25 September 2014

Row No.	Submission	UGNSW Response
	SUBMISSION BY TfNSW and RMS	
1	<p>The TMAP included the following objectives:</p> <ul style="list-style-type: none"> • Adoption of Transit Orientated Development principles to maximize the use of public transport, walking and cycling • Manage the transport impacts of the North Ryde Station Precinct Project on surrounding sites and transport networks • Help reduce reliance on the private motor vehicle <p>TfNSW believes that in order for these objectives to be met the following statements of commitment should be given or otherwise conditions applied by Department of Planning and Infrastructure to achieve the following:</p>	<p>UGNSW supports these objectives for the North Ryde Station UAP and has prepared the development application (DA) in order to deliver one aspect of the proposed transport network contemplated by the TMap and the North Ryde Station Development Control Plan (DCP). In resolving the design of Station Street and Road 38 North as proposed in the DA, UGNSW has had to take into account all of the relevant site constraints and the requirements of the owner of the North Ryde Station South Site, whose co-operation is nec

**INTERSECTION DELHI ROAD & ROAD 38
INTERSECTION ROAD 38 & TRINITY ROAD**
SCALE 1:500

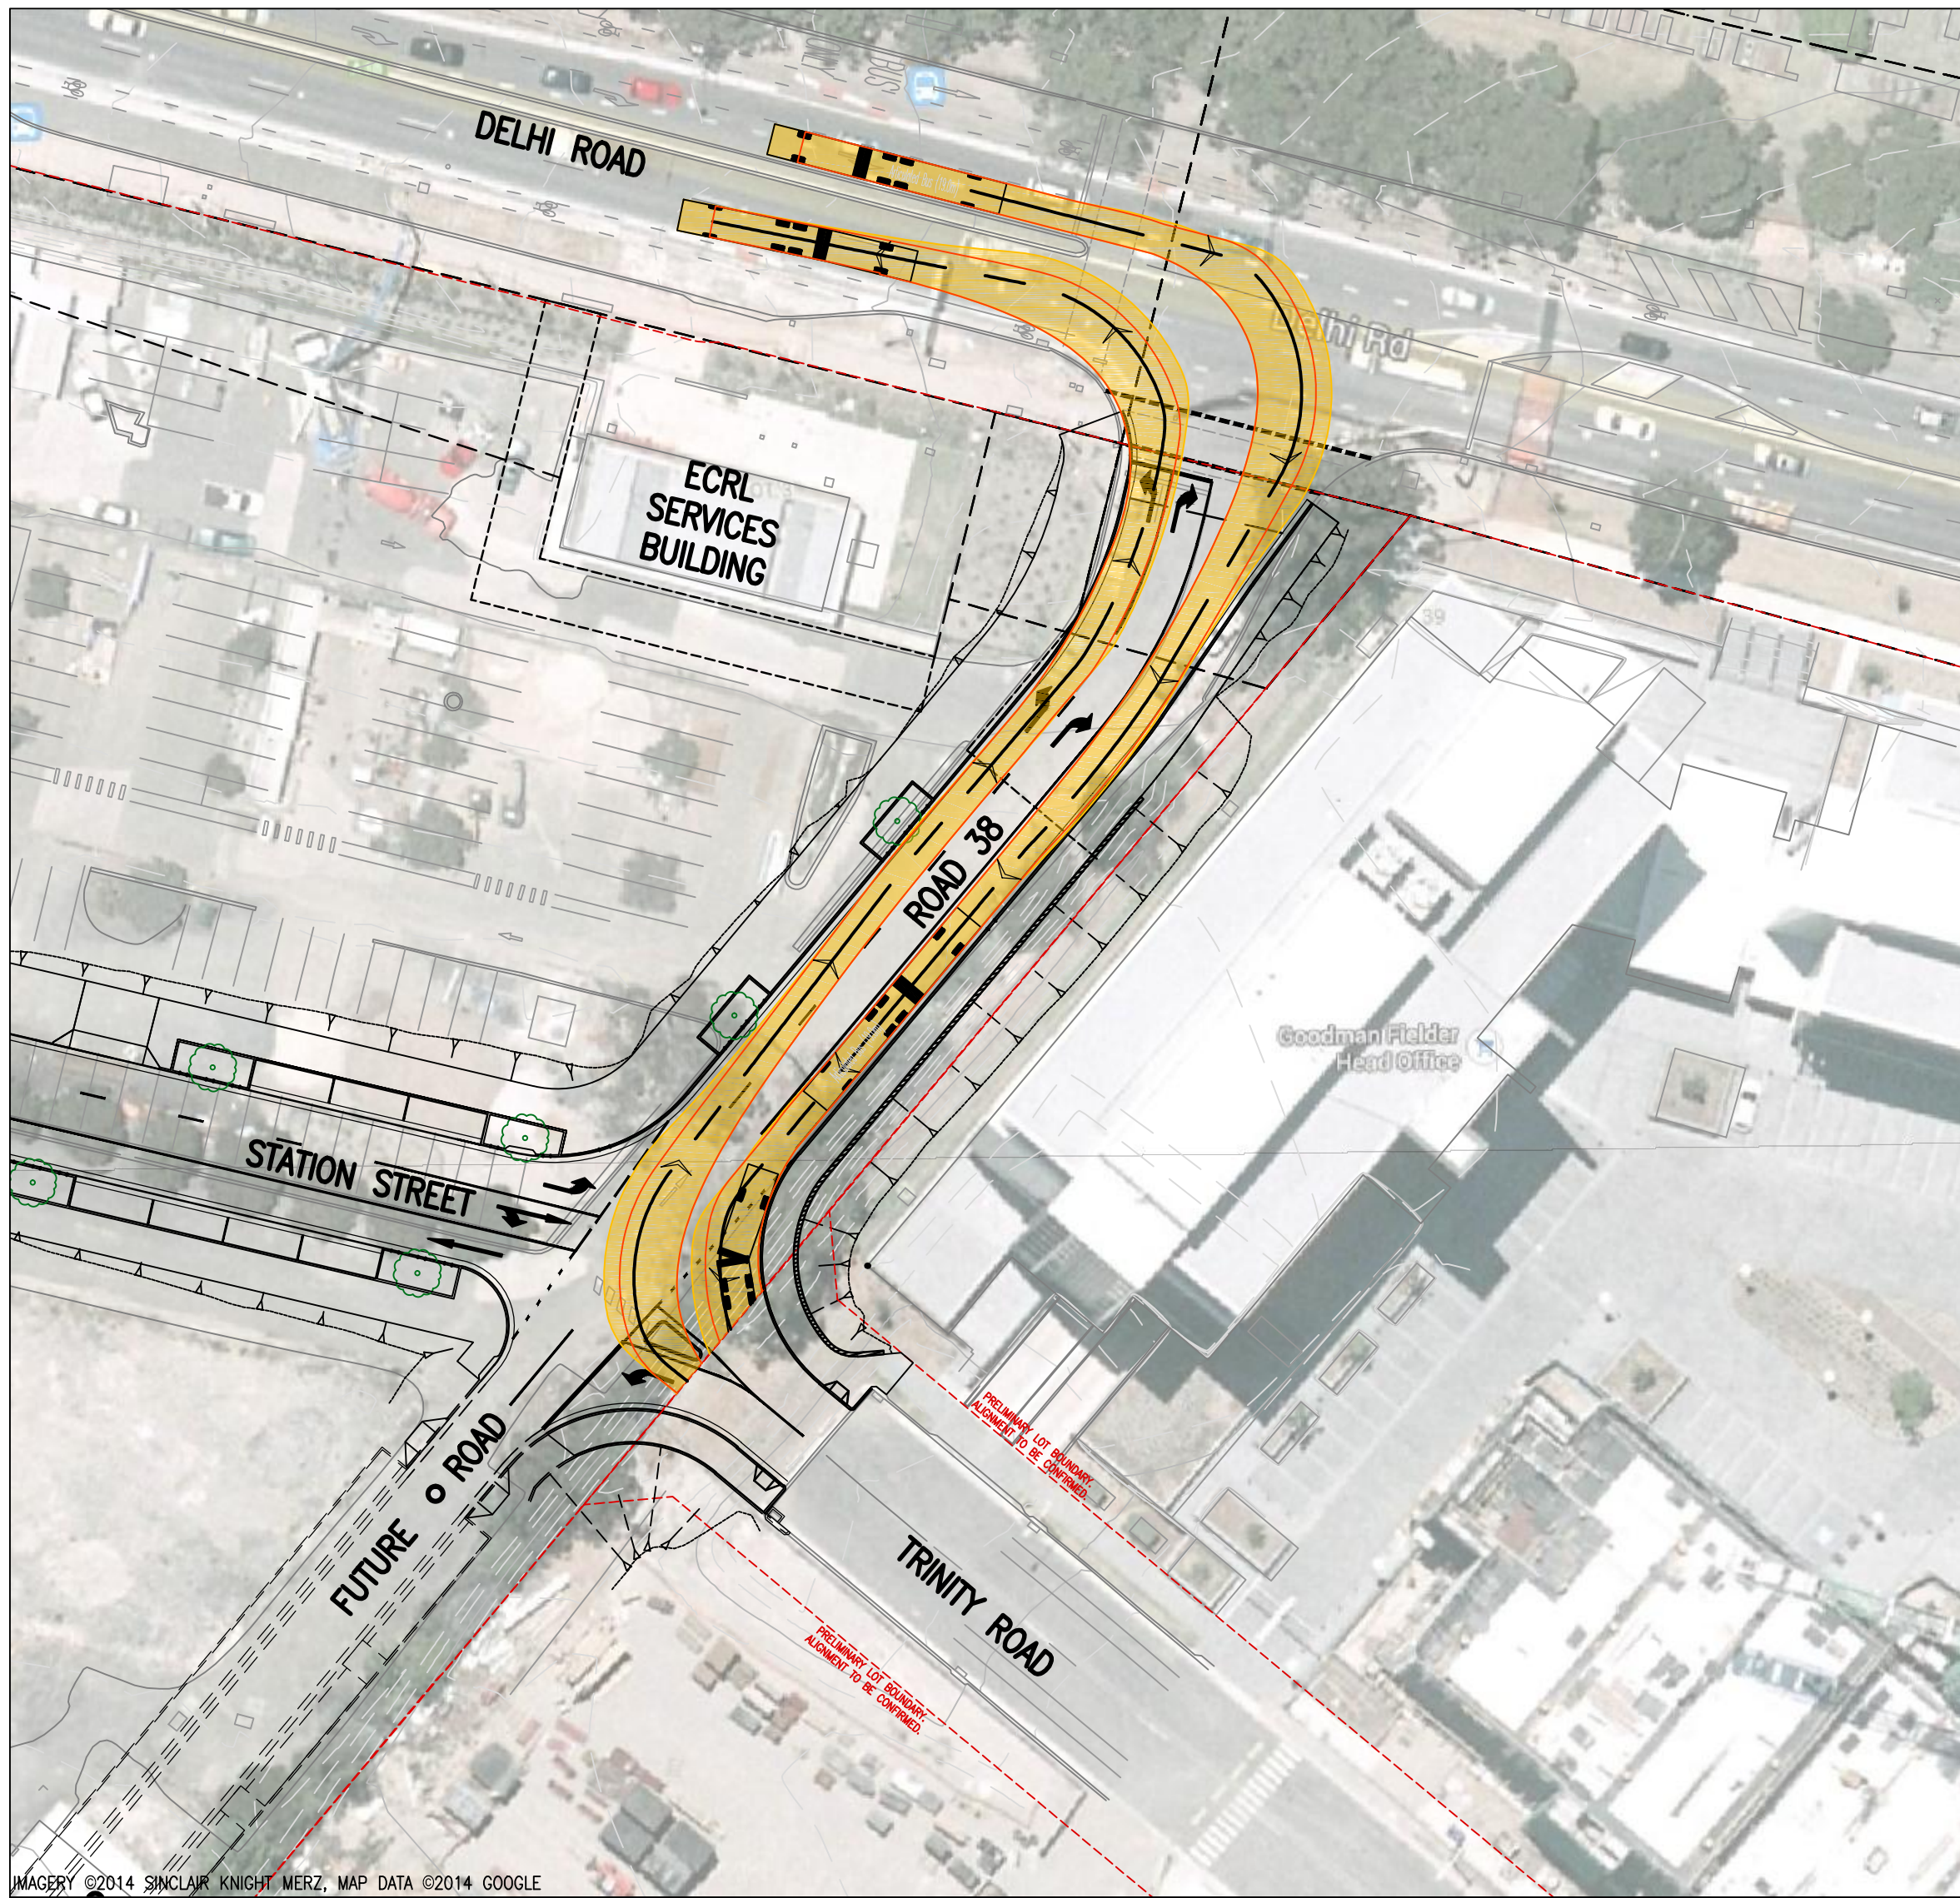
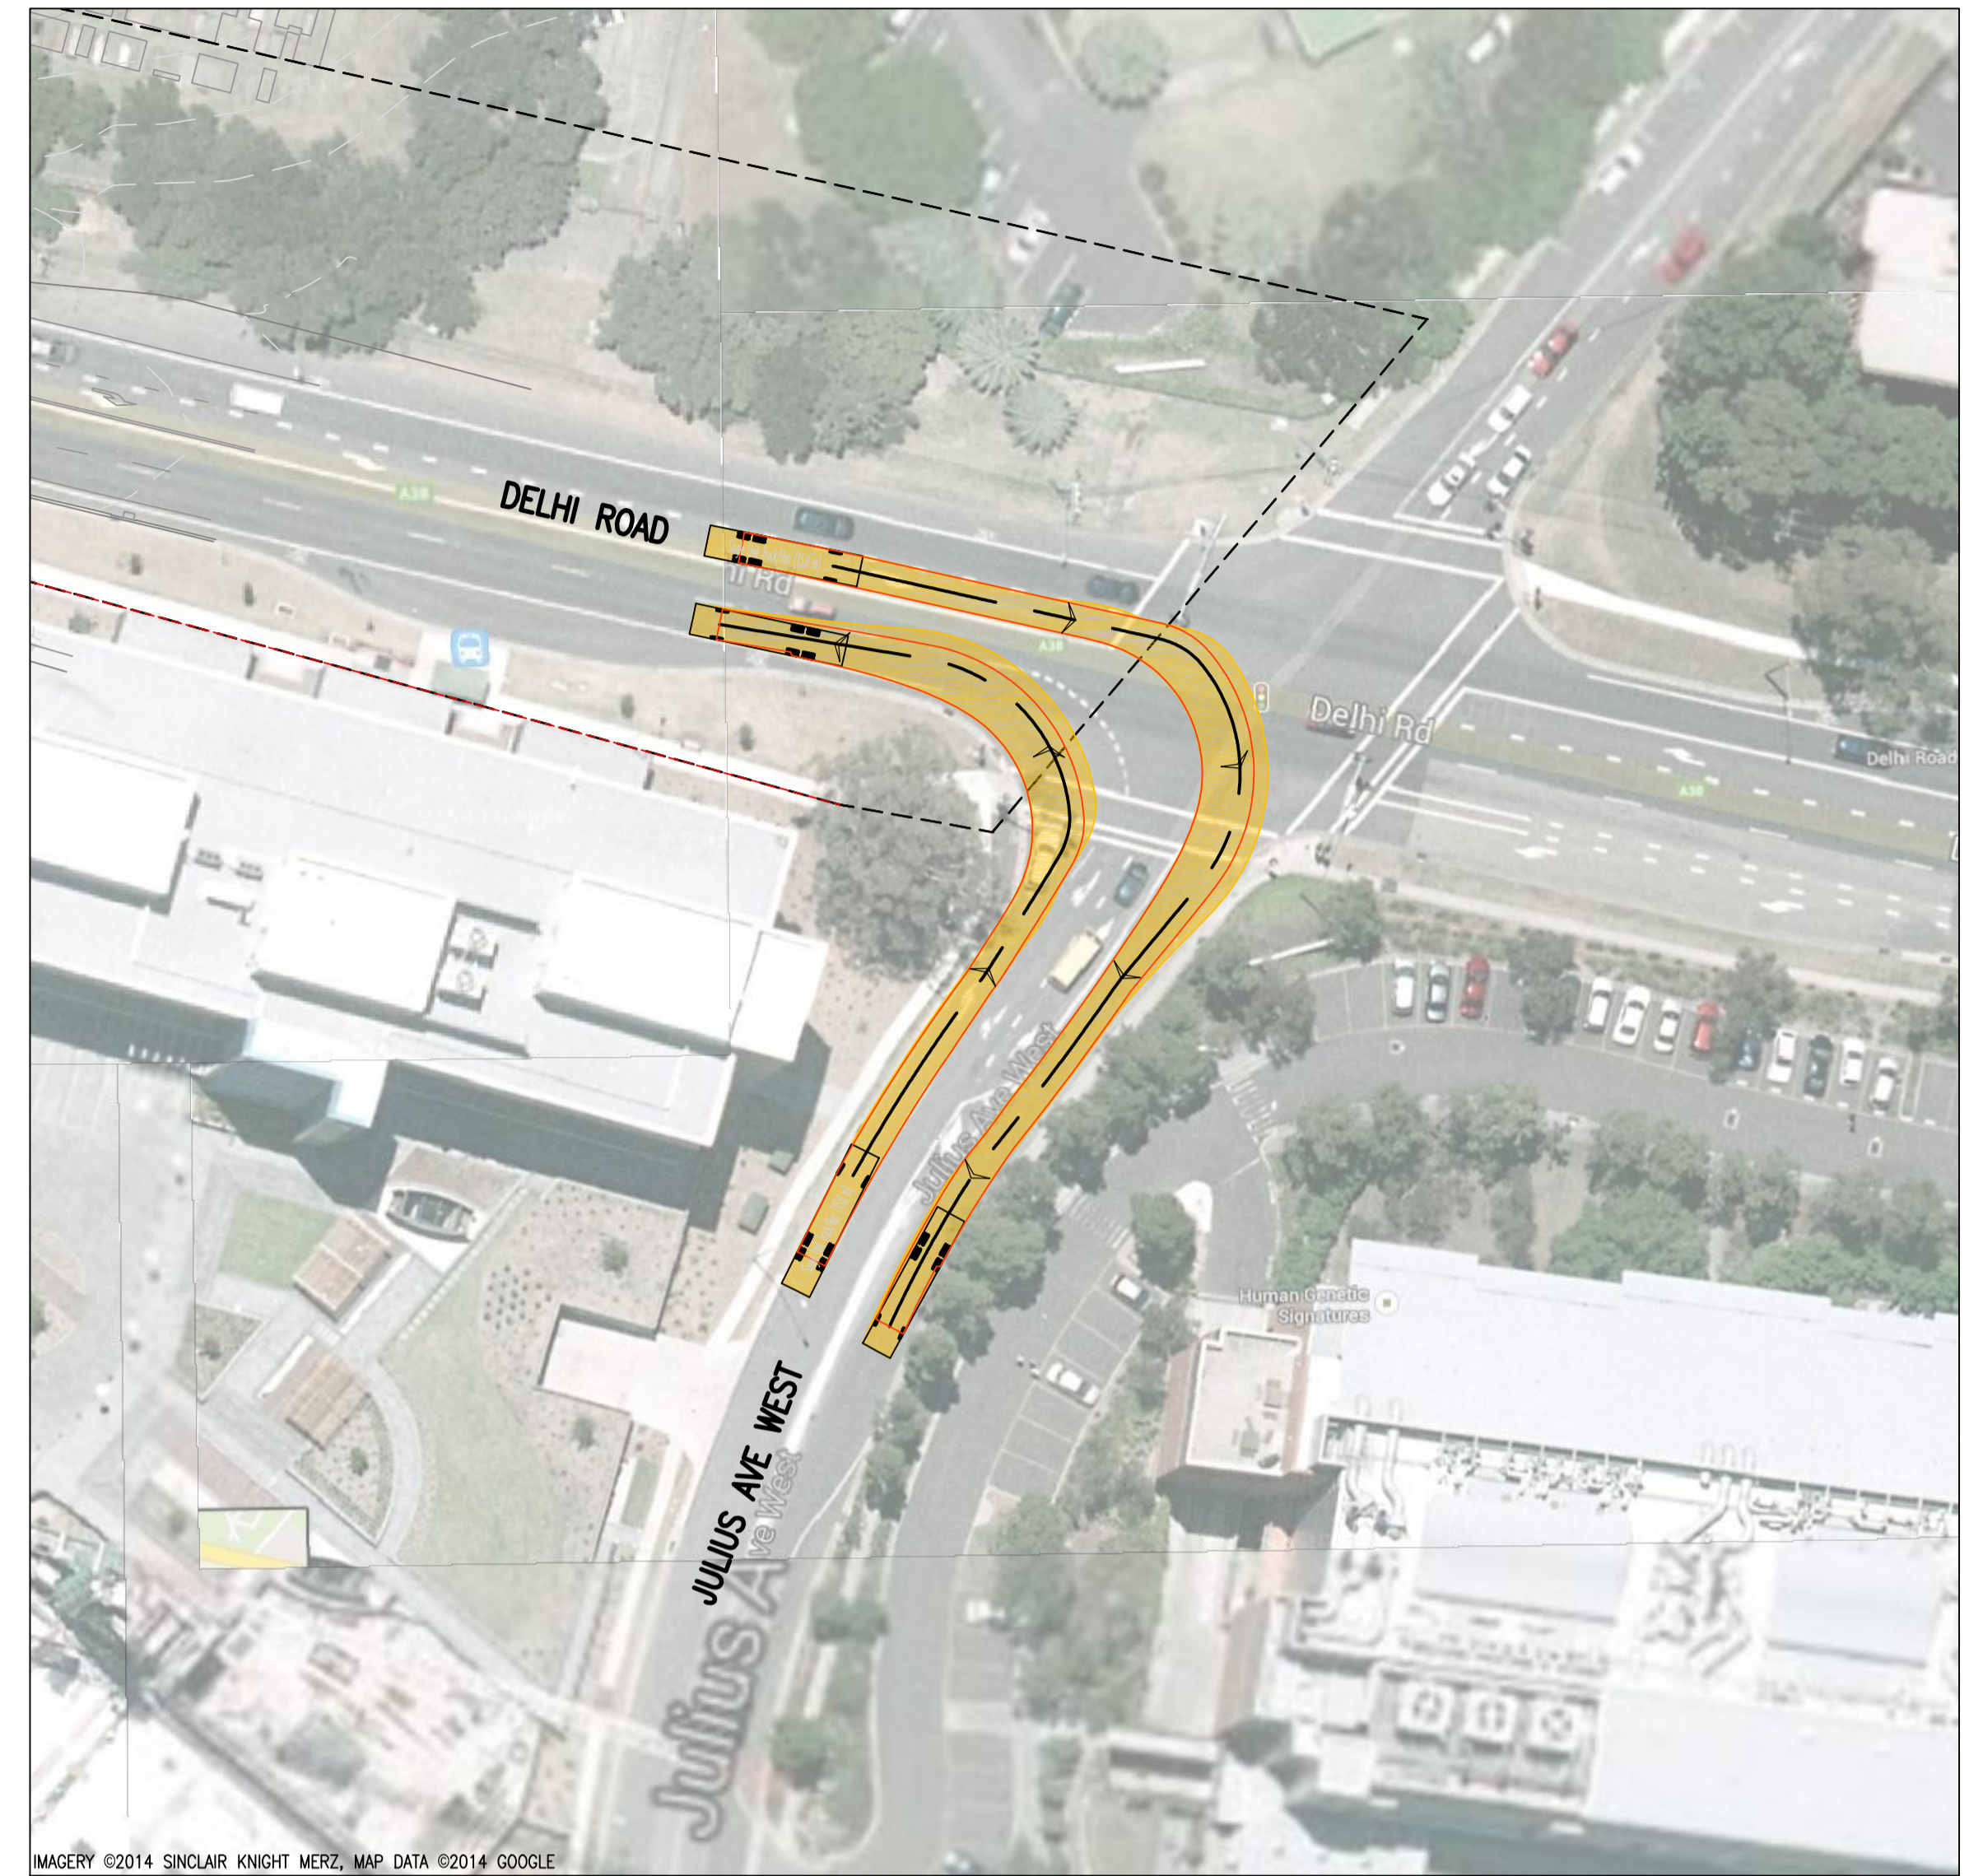
1.3	<p>3. A commitment from UGNSW and the other development partners that the road network comprising Road 38, Road 18 and Julius Avenue will have swept paths capable of accommodating a 14.5 non rear steer bus. TfNSW also requests that a layover area be provided within the above mentioned road network to accommodate two (2) 14.5m buses with draw in/draw out space and provision of suitable signage or kerb indentation if necessary.</p>	<p>UGNSW's engineers advise that Road 38 as shown in Site Layout and Grading Plan Number C3-02 (Revisions 2, 3 and 5) is capable of accommodating a 19-metre articulated bus (adopting the Austroads 19.0m bus turning template with 15.0m turning radius which according to Austroads requires a 15-metre turning circle) in both directions as shown in the attached drawing showing swept paths for a 19-metre articulated bus. However, it should be noted that:</p> <ul style="list-style-type: none"> • If it were proposed to use the northbound swept path for bus circulation, the traffic island in Road 38 which is presently shown within that path in the attached drawing should not be built, and a bus-only right turn should be considered instead; • If it were intended to use both the northbound and southbound paths shown in the attached drawings, it would be necessary to widen the proposed connection of Road 18 to Road 38, but this would be on land outside the Site of this DA; and • The last eastbound bus stop on Delhi Road which is west of Road 38 is too close to Road 38 to comfortably permit a bus which is

<p>departing from that bus stop to make the right turn into Road 38.</p> <p>The practical consequence of the foregoing is that an end-of-bus-route turning loop for a bus service could be utilised by having eastbound buses in Delhi Road opposite the rail station proceed easterly, past Road 38, and turn right into Julius Ave (West or East), then enter the eastern end of proposed Road 18, turn right into Road 38 and then left onto Delhi Road and to proceed in a westerly direction. Both of these loops (that is, whether via Julius Ave West or East) can accommodate:</p> <ul style="list-style-type: none"> • a 12.5-metre rigid bus in both directions; and • subject to widening of the proposed connection of Road 18 to Road 38, a 19-metre articulated bus in both directions. <p>A swept path analysis for a 12.5-metre rigid bus is also attached in substantiation of this advice.</p> <p>UGNSW has no means of controlling other landowners or other existing or proposed public roads. If the bus network route suggested above were implemented, this would solve the problem with which TfNSW's comments appear to be concerned. In addition, Country Garden Australia Pty Limited has asked that consideration be given to using an end-of-bus-route turning loop which requires eastbound buses on Delhi Road to turn right into Julius Avenue West, proceed around the round-about in Julius Avenue West and exit Julius Avenue West by a left turn into Delhi Road.</p> <p>It is also important to note that the amount of land required to accommodate a bus layover area would impose substantial limitations on the future development of the Station North Site. Bus layovers in Station Street were not contemplated in the T Map and, in UGNSW's submission, should not be contemplated now.</p>
